From: [Francine Curd](#)
To: [Rachael Stevie \(CD\)](#)
Subject: RU-22-00002 East Peak - Application
Date: Friday, April 22, 2022 4:54:42 PM

Comments on: RU-22-00002 East Peak - Application
Submitted by: Francine Curd
721 Hyak Dr. E.

Thank you for giving me a chance to comment on the East Peak Reasonable Use Variance on "Parcel B". East Peak Development, LLC is requesting a reasonable use exception on Parcel B, to the 150-foot buffer and 15-foot setback for a Type III wetland and the 50-foot buffer and 15-foot setback for a Type Ns stream. In my opinion the "Reasonable Use Variance" should not be granted.

DEVELOPMENT, STORMWATER AND
PARKING PLAN - PARCEL B

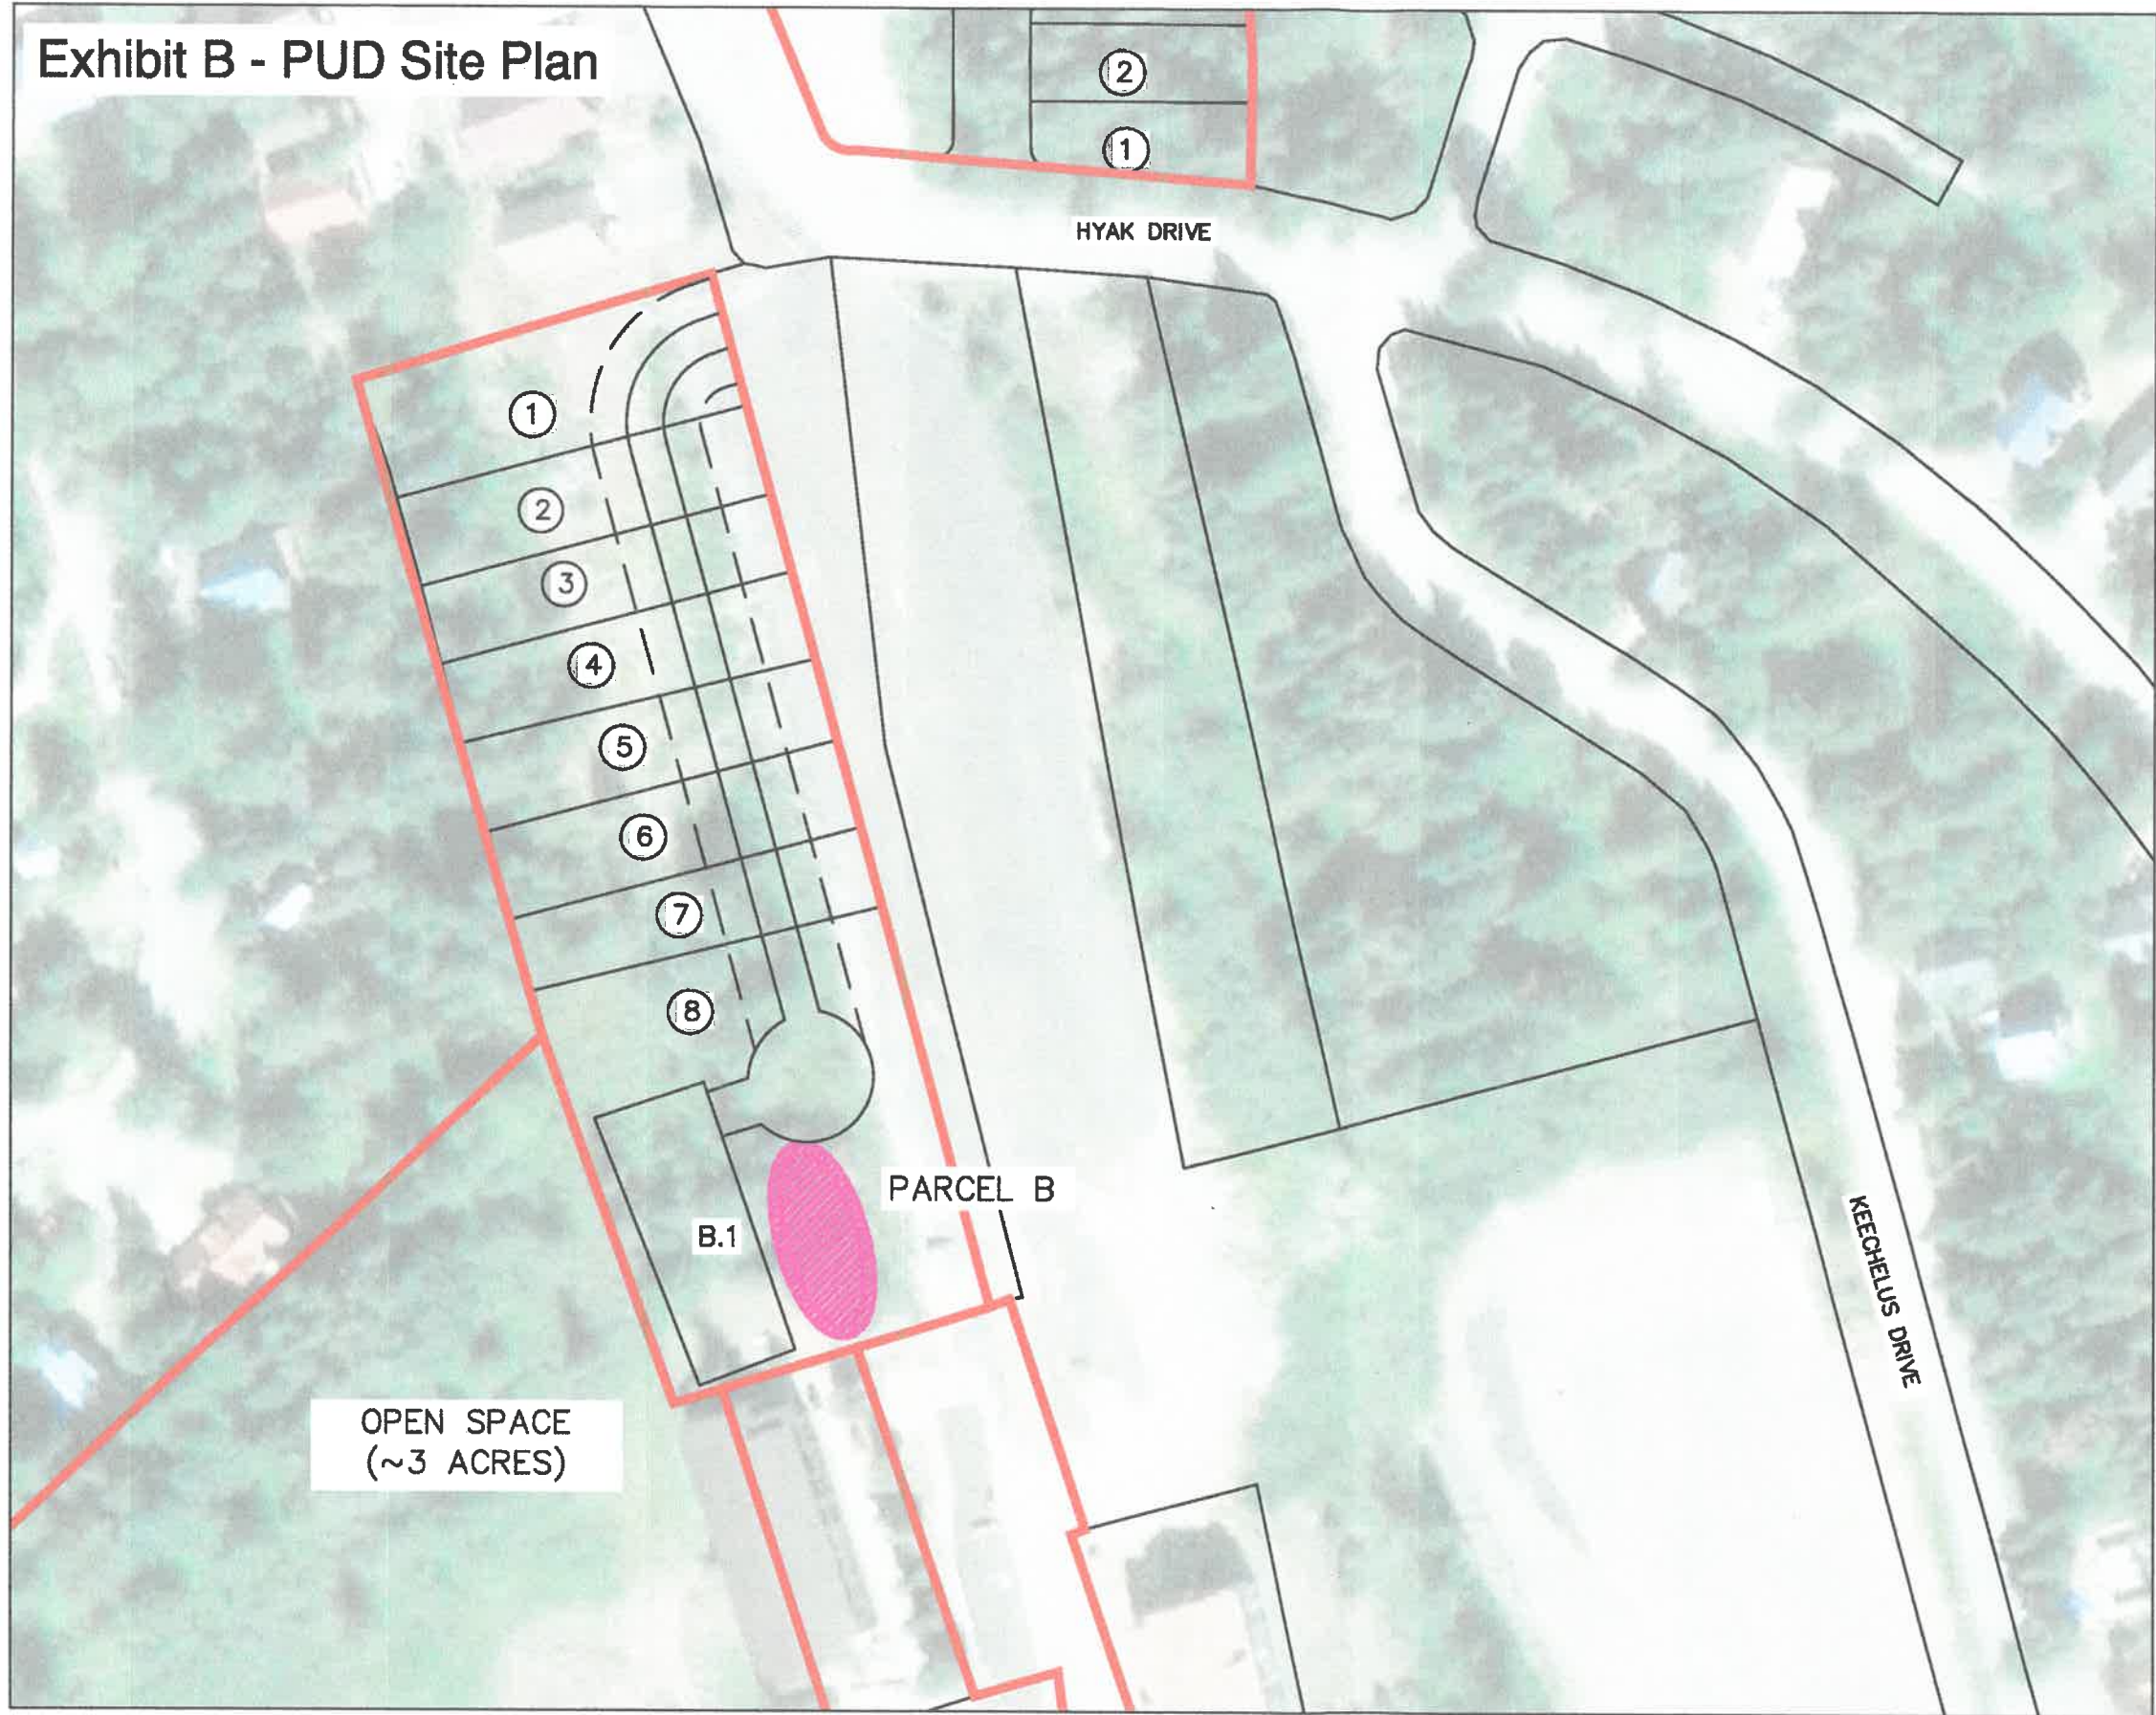
In the "Project Narrative" for the Reasonable Use Variance, East Peak Development, LLC states in their response the Hyak PUD Final Development Plan was approved in 2018 by the Kittitas County board of Commissioners showing a 50 unit condo building and 8 detached single family lots. It further states "The approved density was based on an in-depth analysis of surrounding uses". However, during the "in-depth analysis" the original project plan failed to identify the wetland which the proposed 50 unit condo building was to be constructed upon.

East Peak Development incorrectly states in the project narrative for the 2018 Hyak PUD Final Development plan, that documentation from their consultant stated no wetlands were present, satisfying the Kittitas County CDS condition. The county accepted this incorrect statement submitted by the developer, and the wetland condition was incorrectly met as per the FPUD documents.

There are no elevation profiles for any structures.
There is no analysis of loss of permeable surfaces.

The main drainage plan seems to be several 2 foot ponds. Does this low depth not require fencing?
